COMMUNITY SERVICES DEPARTMENT

April 8, 2020

Subject: Creekside South at Lorson Ranch PUD (PUDSP201)

PARK LANDSCAPE PLAN
 1:20 Scale

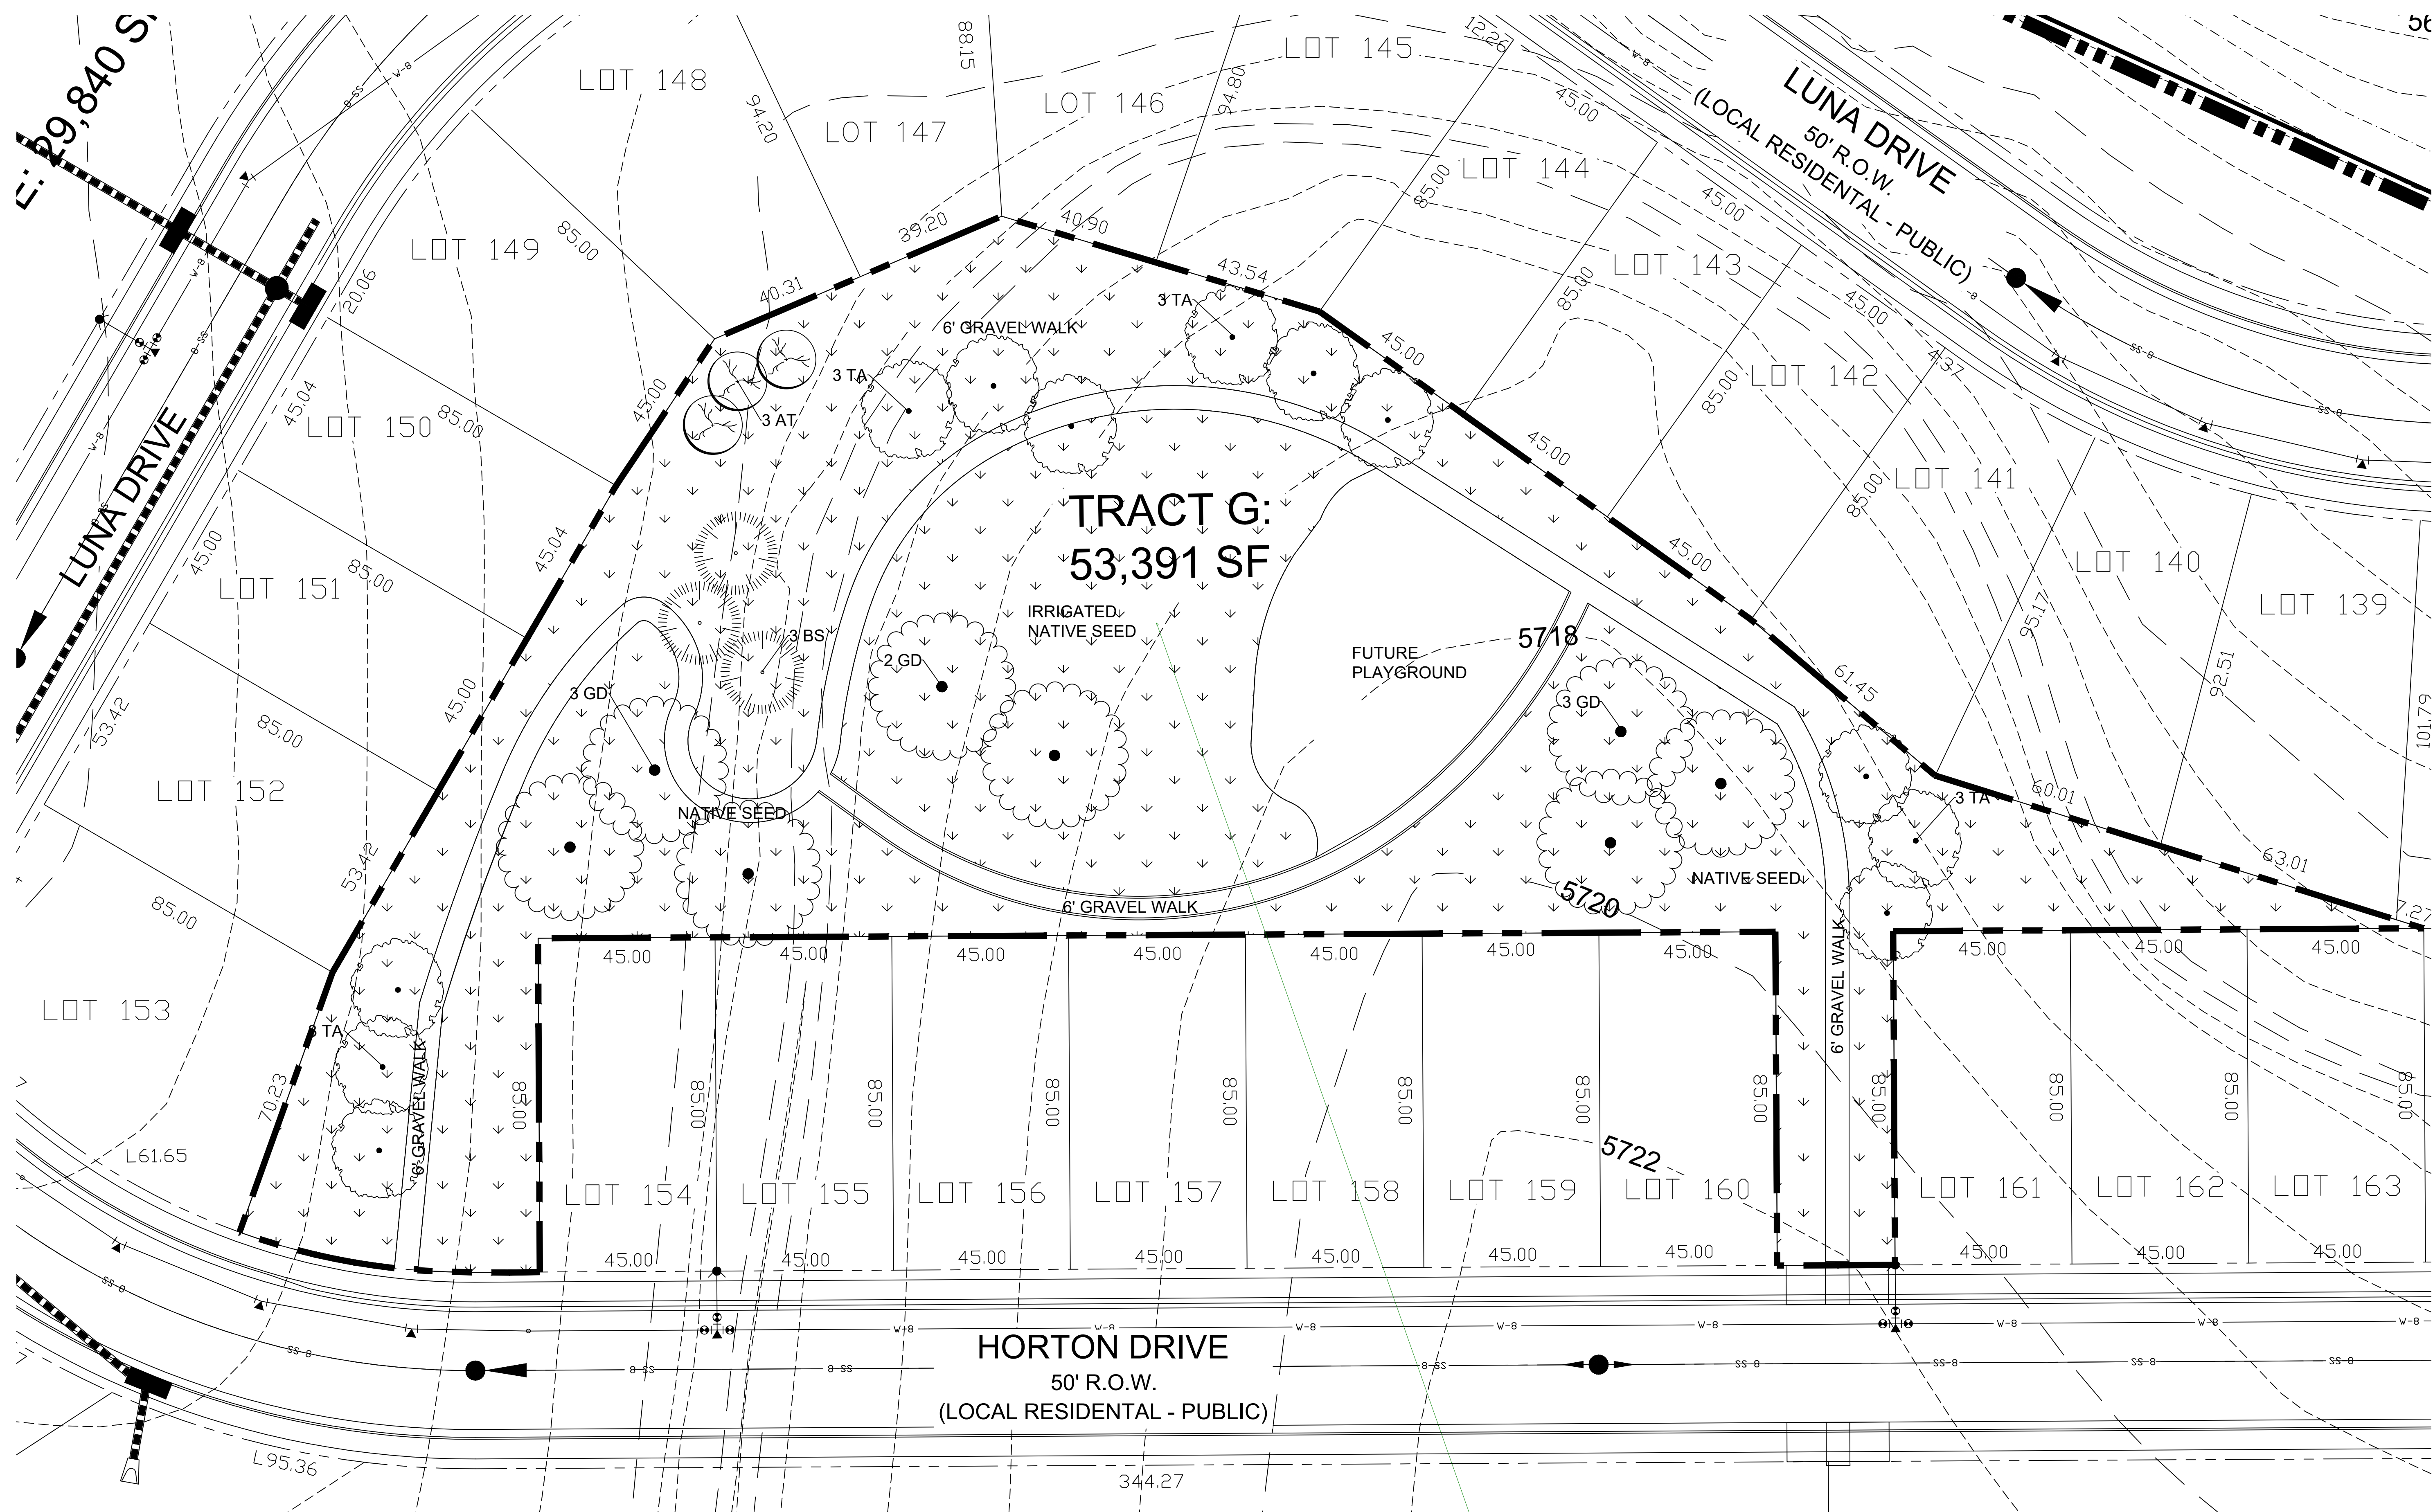
The applicant is proposing to develop a pocket park in Tract G. Staff appreciates this inclusion and the benefits it provides to the residents within Creekside South. A park lands agreement may be considered as part of a future final plat.
